DEVELOPMENT REVIEW BOARD
SUPPLEMENTAL SUBMITTAL

PROJECT NO. PR-2020-004414

Application No. SI-2020-00917

DESCRIPTION: Revised Site Plan and Infrastructure List addressing DRB Comments:

AS100

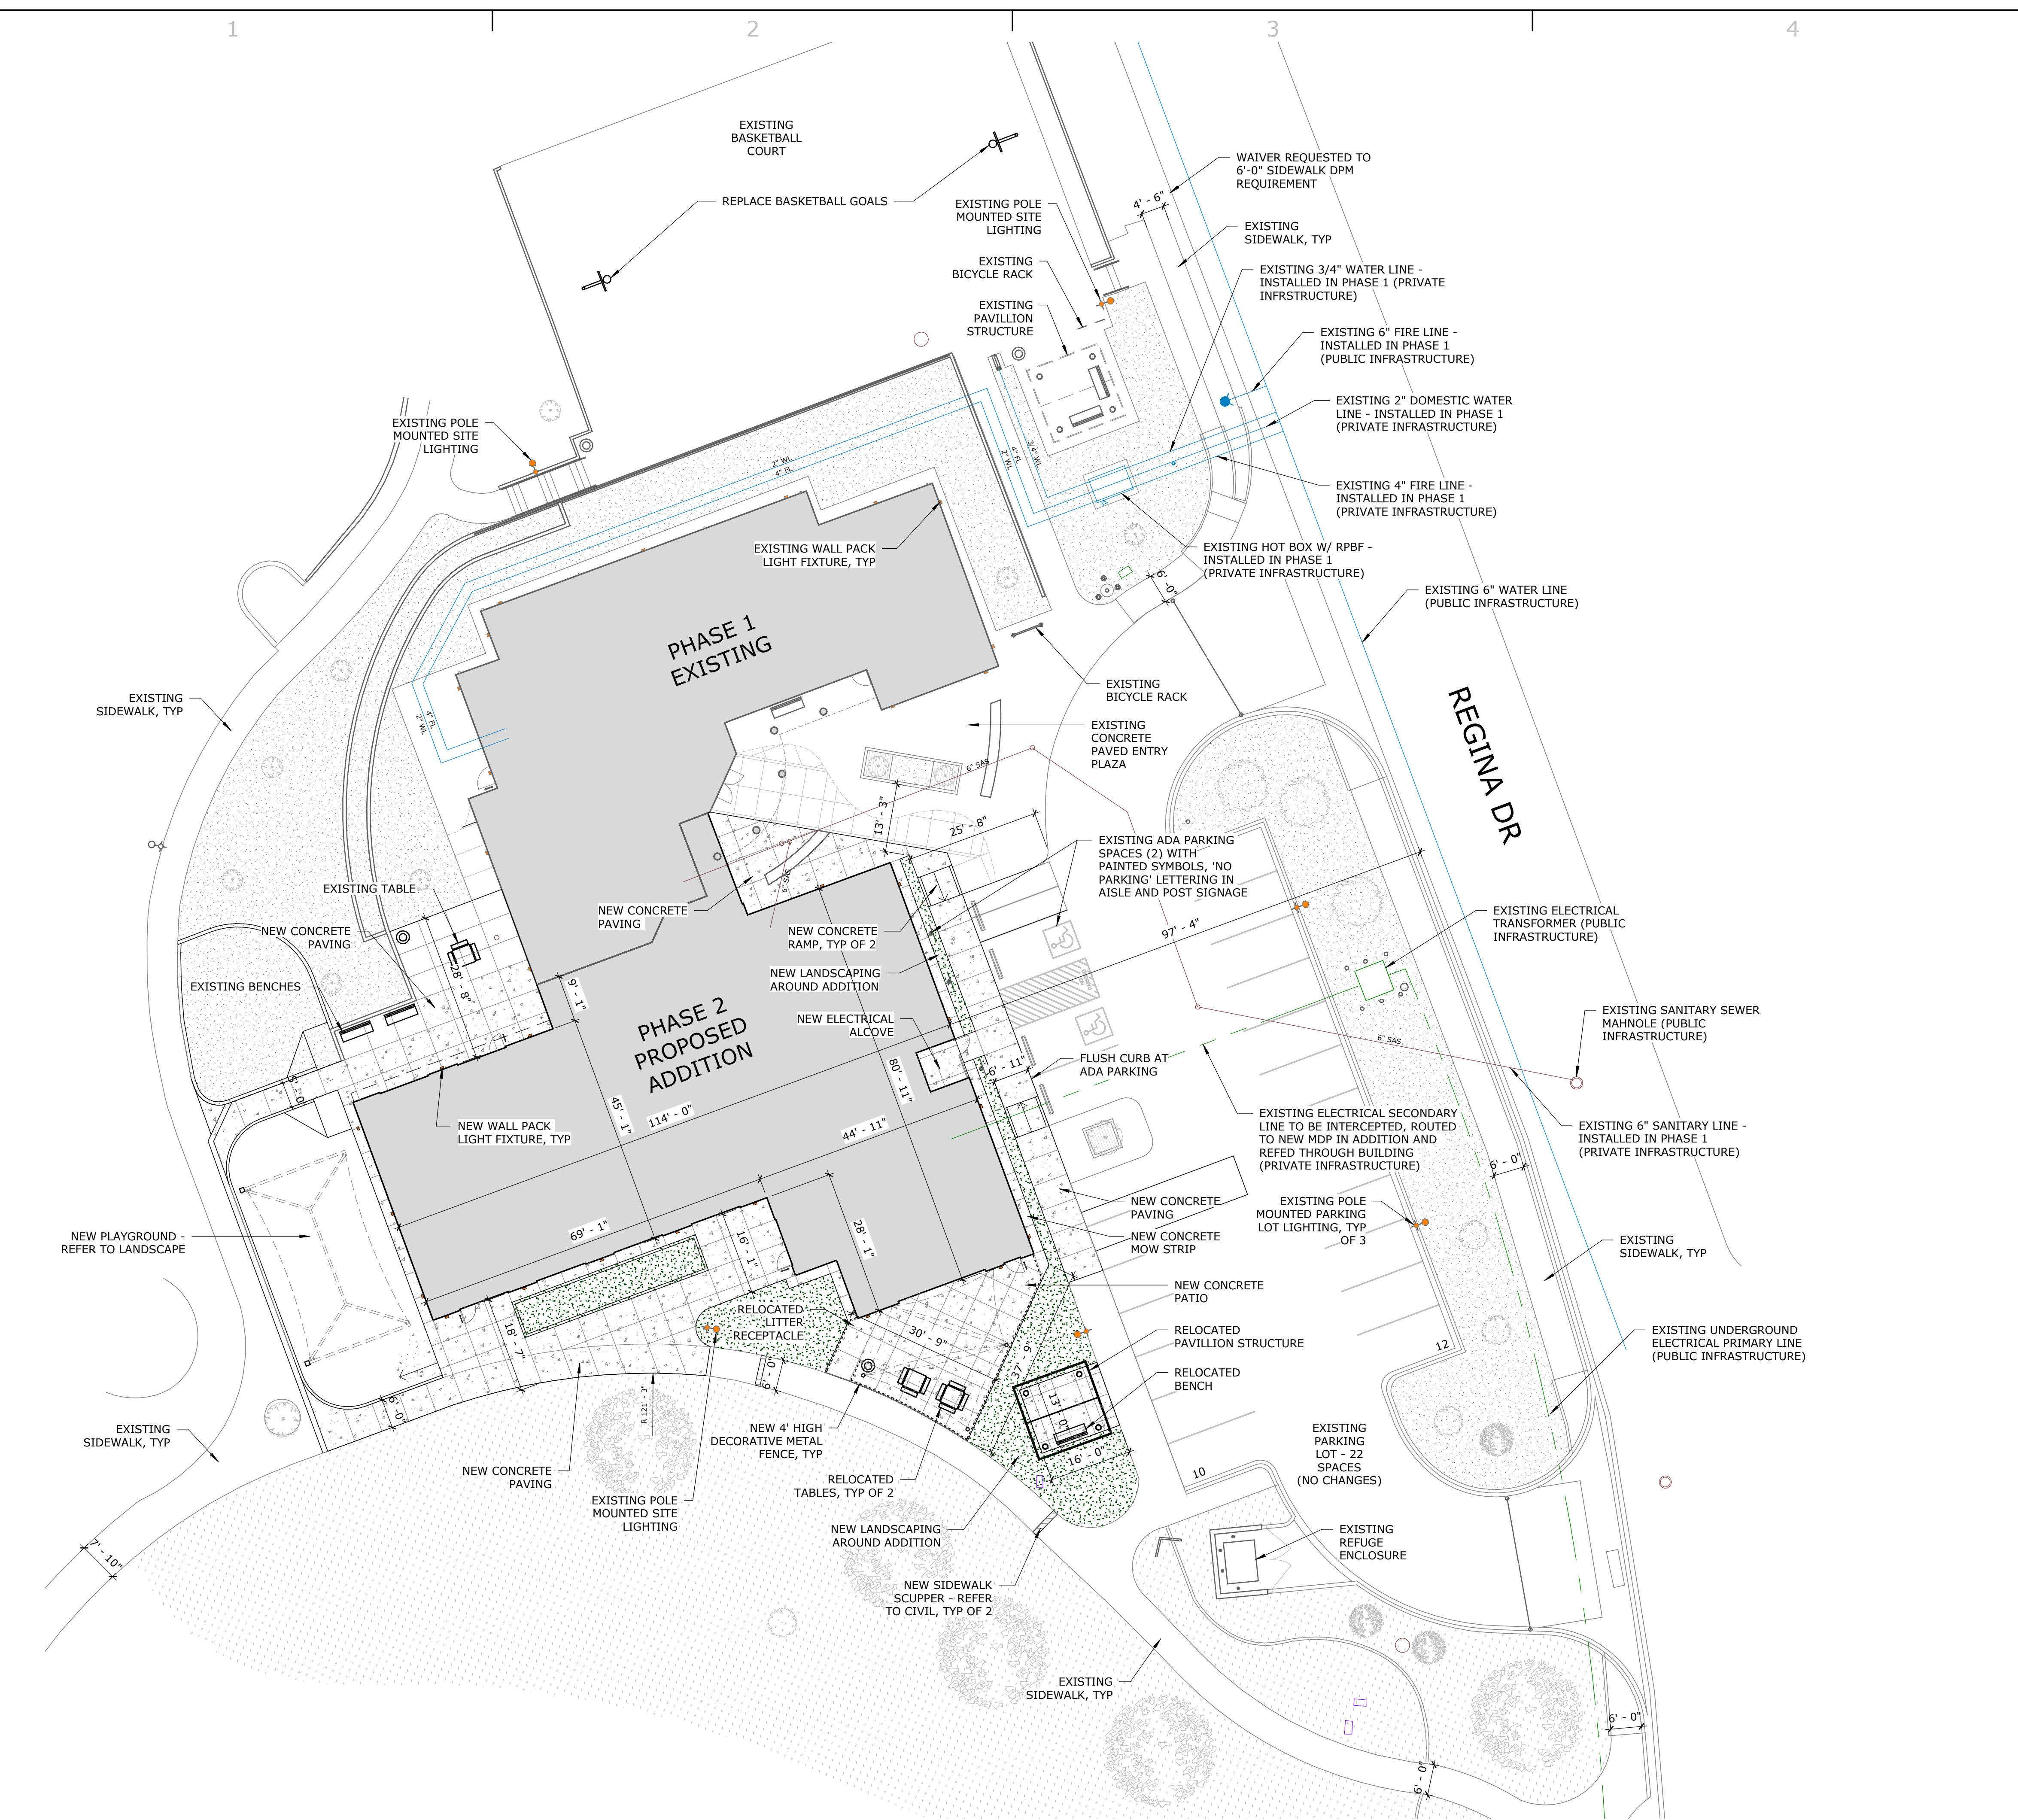
Hammerhead turnaround/street extension for Rincon with sidewalk on attached Infrastructure List; dimensions for ADA pathways from parking to building entrance and right-of-way added to site plan sheets; sidewalk cross-slope indicated in detail B4/A500; turf field acreages added to overall Site Plan; site lighting added to Site Plan Sheet AS100; and note added to Landscape Plan Sheet L102 describing compliance with CPTED comments.
